Subject: RE: amendments to B3/B5 access road North Littlehampton

I write to confirm acceptance of your Drawing A/PHLITTLE.2/IDR-GA Rev 'G' (as amended) with the additional visibility splays for pedestrians and cyclists at the formal junctions, for planning purposes. I also confirm acceptance of the landscaping proposals as shown on this drawing. Neil Crowther will advise which planning application(s)/condition(s) this satisfies.

Tim Townsend | Senior Planner, Planning Applications - Strategic Development, West Sussex
County Council

PROPOSED S278 HIGHWAY WORKS
AMENDED IDR GENERAL ARRANGEMENT DRAWING

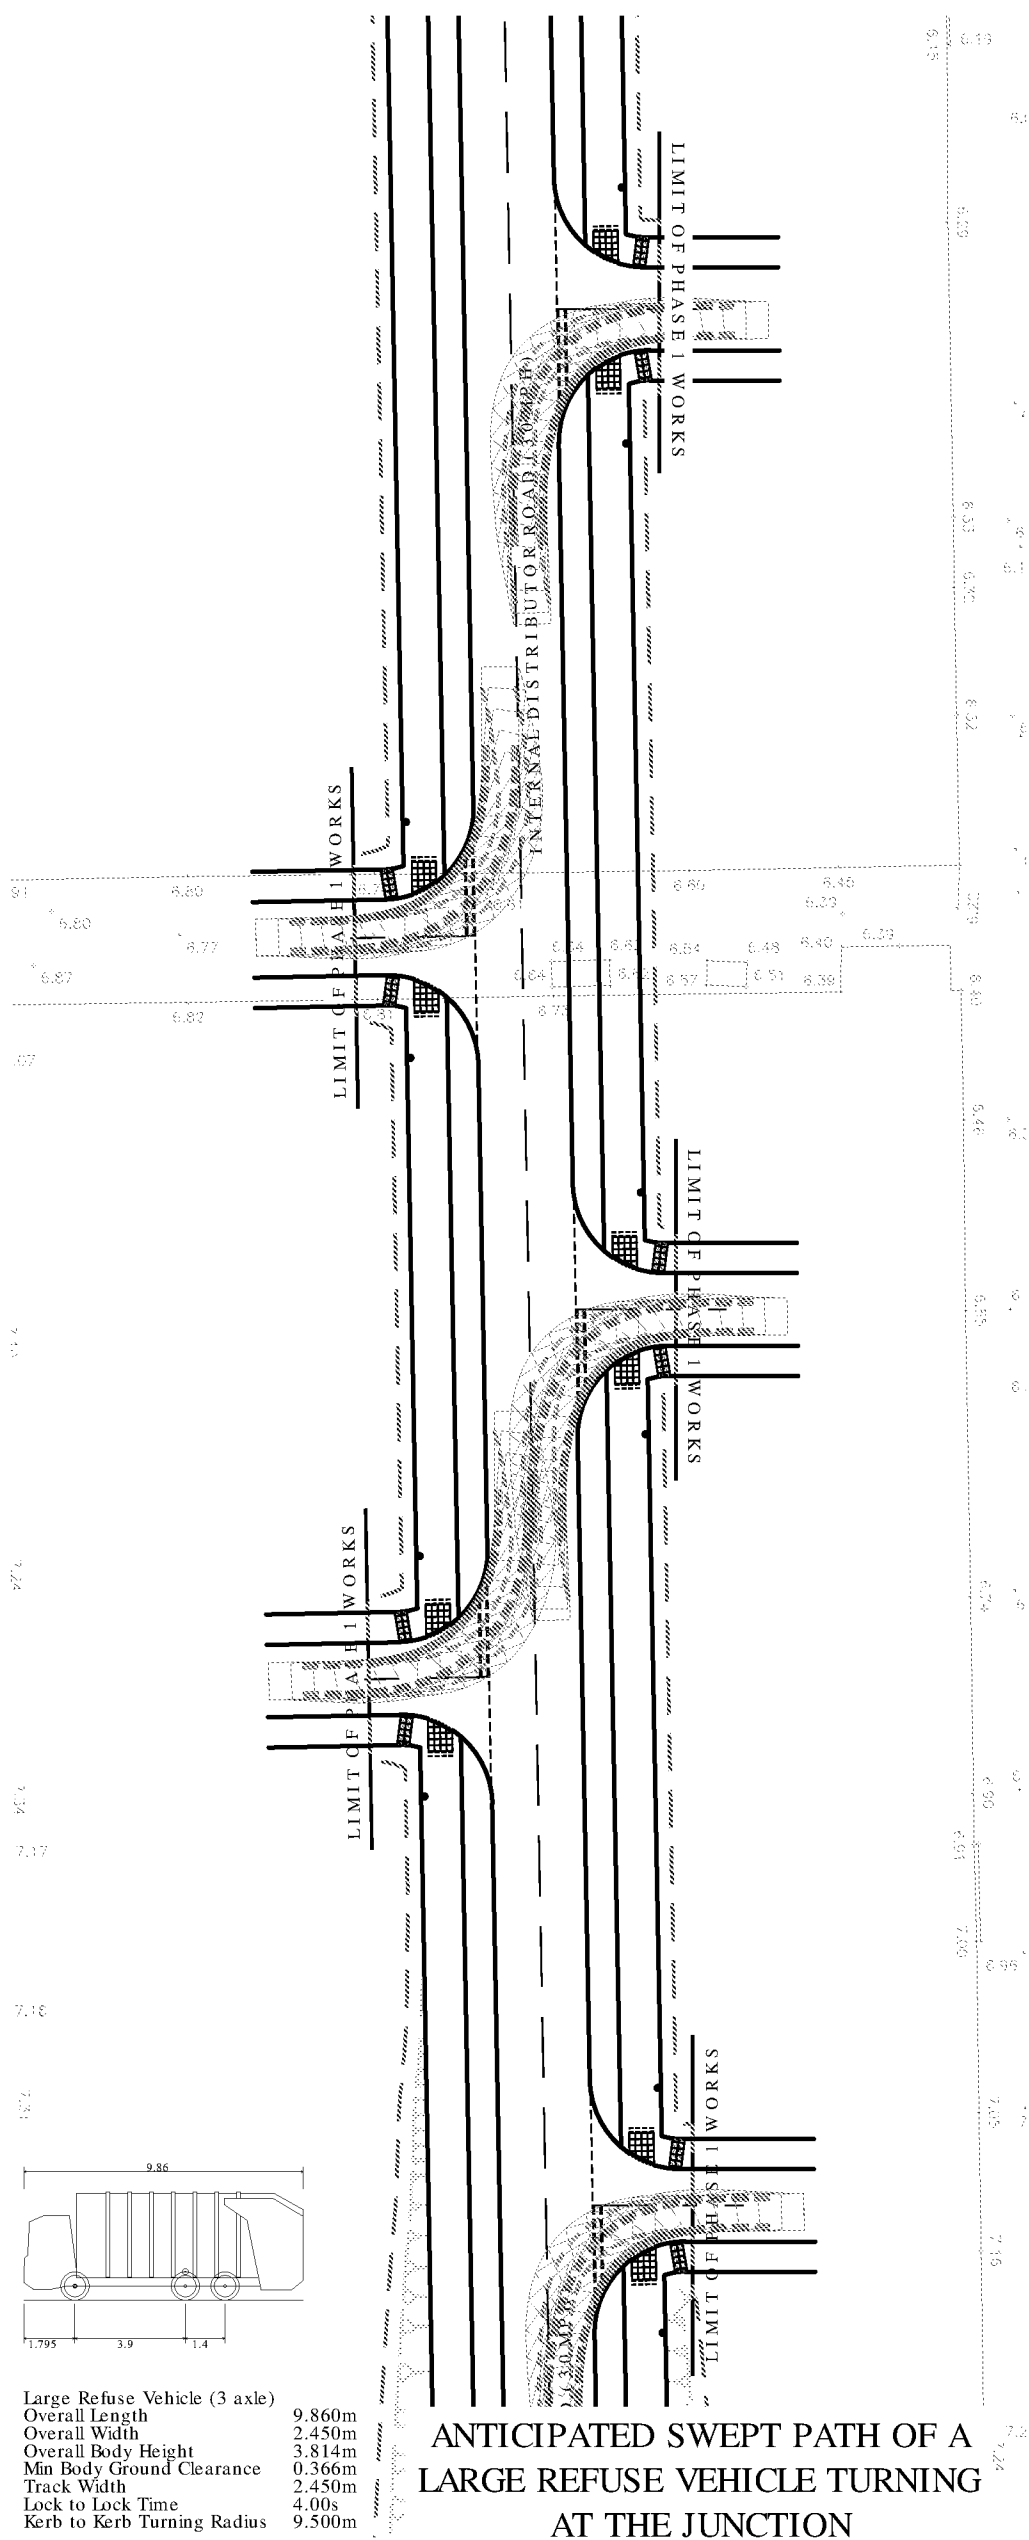
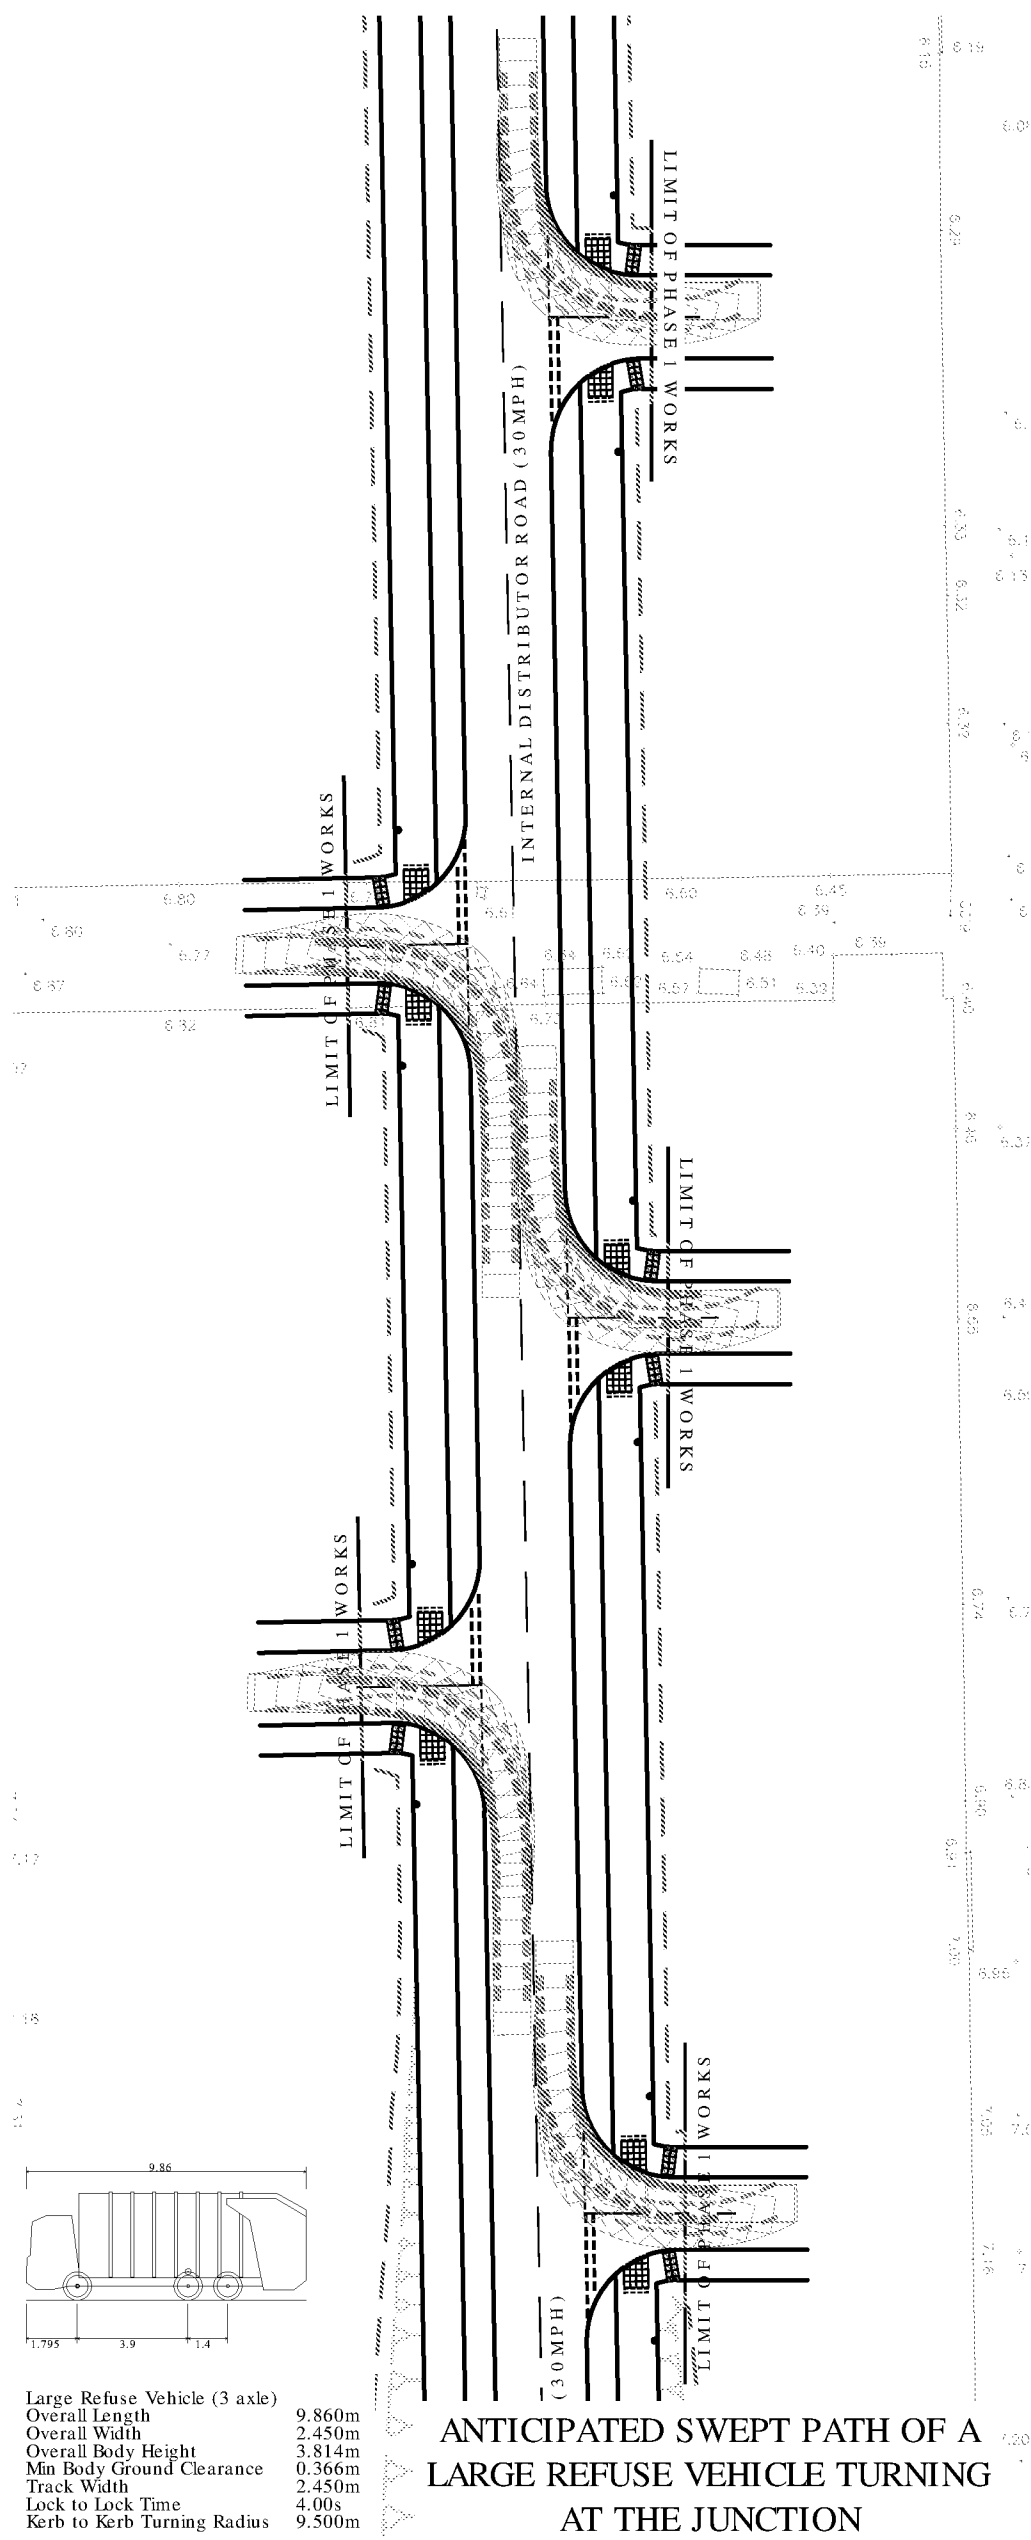
3. Achievable Cycle intervisibility splays based on min 1m back from the channel line; Your plans show visibility from the crossing points. What we require (in addition to what you've shown) are splays across the corners of the plots so pedestrians and cyclists are intervisible to one-another. The guidance contained in the LTN and TD documents is often difficult to interpret. Therefore, taking a practical view of the situation we are of the view that 2.4m x 2.4m splays should be shown across each plot corner adjacent to the formal junctions with maximum height of any walls, fence and/or planting being 0.6m in these areas. This is based on the assumption that cyclists will be slowing for each junction which will bring their speed down, giving both user types a reasonable degree of intervisibility at these points. Of course, the remaining boundary treatments for the properties fronting the north-south road should be no higher than 900mm. Please see my sketch on the attachment to aide you for the junction corners.

A considerable number of trees is shown within the verges on both sides of the IDR, some of which are within designated junction visibility splays.

Whilst we note that the trees are intended to be of relatively small girth and have clear stems, they will inevitably have some impact on sightlines; this effect will be greater the closer they are to the junction and will increase with time as the trees grow. This will increase the risks of vehicles emerging from the side roads being struck by passing traffic, and of cyclists approaching a junction along the shared path being concealed from drivers intending to turn into the side road.

Do not plant trees within the visibility splays.

The crux of the issue contained in the summary above is the section I have highlighted. Any risk is of course greater in the leading traffic direction at the junctions because traffic is on that side of the road, although there is still risk in the trailing traffic direction – albeit perhaps less-so because vehicles would in normal circumstances be on the opposite side and more intervisible as a result. If you want to retain the trees, you will need to demonstrate that sufficient visibility is available for the prevailing conditions and the types of users expected. What can you do to the design that avoids losing trees? Is it possible to re-locate the first/nearest tree to each junction in the *leading* traffic direction – perhaps moving them further away and ‘opening-up’ the visibility ‘envelope’? Would that satisfy the Audit Team? Please put this to them for their reply. ***Neil (Crowther), for aesthetic/planning reasons, would you want the nearest tree in the trailing traffic direction also moved to correspond with the other side of each junction?***

2. **Tree locations and interaction with street lighting requirements** – still awaited from you following your discussions with SSE.
3. **Pedestrian/cycle intervisibility requirements at road junctions** – This is still required.
4. **Tree canopy heights** – The tree type states a 2.1m clearance (base to bottom of growth when mature). WSCC still recommend 2.4m to avoid clashes with cyclists and road users. Please amend.

3 – As requested, please see attached the amended drawing ref **A/PHLITTLE.2/IDR-GA Rev G** amended to indicate the additional vision splays.

1. Updated street lighting layout received from SSE dated 13/5/16;
2. Subsequently amended tree locations to avoid street lighting and maximise sight lines;
3. Achievable Cycle intervisibility splays based on min 1m back from the channel line;
4. Effective visibility splays indicated from 2.4m to a point located in the associated centre of lane based on the trees being planted in the middle of the 2m verge and with a girth not exceeding 60cm, which is the maximum girth as advised by the landscape consultant for a 25 year old tree.

Having looked at your revised plan (A/PHLITTLE.2/IDR-GA Revision E), in our opinion the relocation of the trees further away from the junctions is a worthwhile improvement that satisfactorily addresses the concern we raised in Problem 2.3.

Item 2 – The amended SSE design has been received. The street lighting has been moved forward into the verge to mitigate against the provision of trees. We have also subsequently relocated trees further away from the lighting to assist with this.

Item 3 – Pedestrian/cycle intervisibility at the junctions has been added in orange as requested indicating visibility from the min 1m back from the channel line as described in *Cycling England Design Portfolio B.04 Junction and Forward Visibility*.

Item 4 – We have spoken with the landscape consultant and in relation to encroachment, I am advised by the landscape consultant that “As you can see in the picture below a heavy standard with 2m clear stem is very narrow and won’t reach past the edge of the road/cycleway. The same tree at 25 years old will only have a canopy width of 2.5m only reaching just over the edge of the road/cycleway. At 25 years old it will have a clear stem of over 2.4m.” In consideration of the statement regarding the tree, I assume that a clear stem of 2m is acceptable as the spread of the tree is retained within the proposed 2m verge width. (Photo below)
